Department of Environmental Health

**RE: Harnett County Land Use Application #10-5-24075**

Based on the criteria set out in Title 15A, Subchapter 18A, of the North Carolina Administrative Code, Rules .1950, the evaluation indicated that the site is **UNSUITABLE** for the addition requested. Therefore, your request for an existing tank is **DENIED**. The site is denied based on the following:

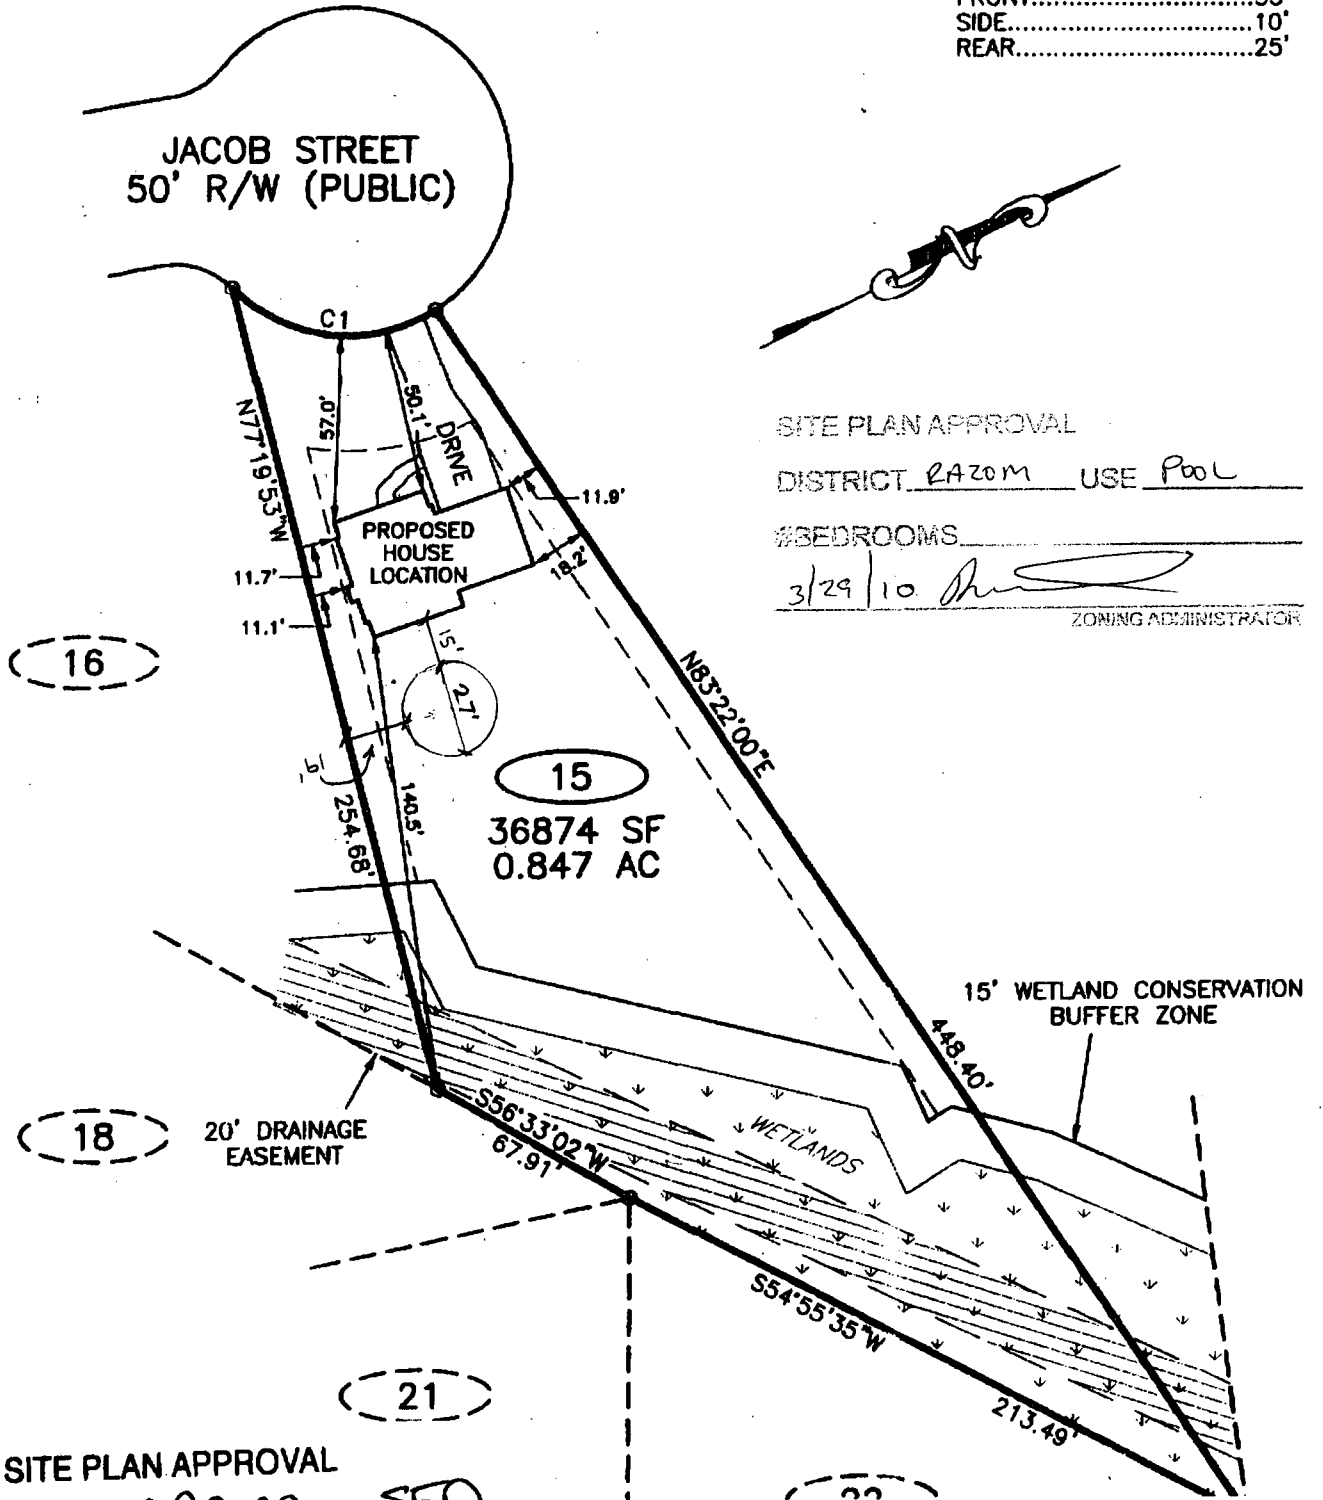
- 15A NCAC 18A.1950a {16} - Any swimming pool must be 15' from any part of septic system.**
- 15A NCAC 18.1945{b} - Each lot shall have original septic system plus repair area.**
- 15A NCAC 18A.1950 {10} - Any building to be 5' from drain line.**
- 15A NCAC 18A.1950{c} - Nitrification fields and repair areas shall not be located under paved areas or areas subject to vehicular traffic.**
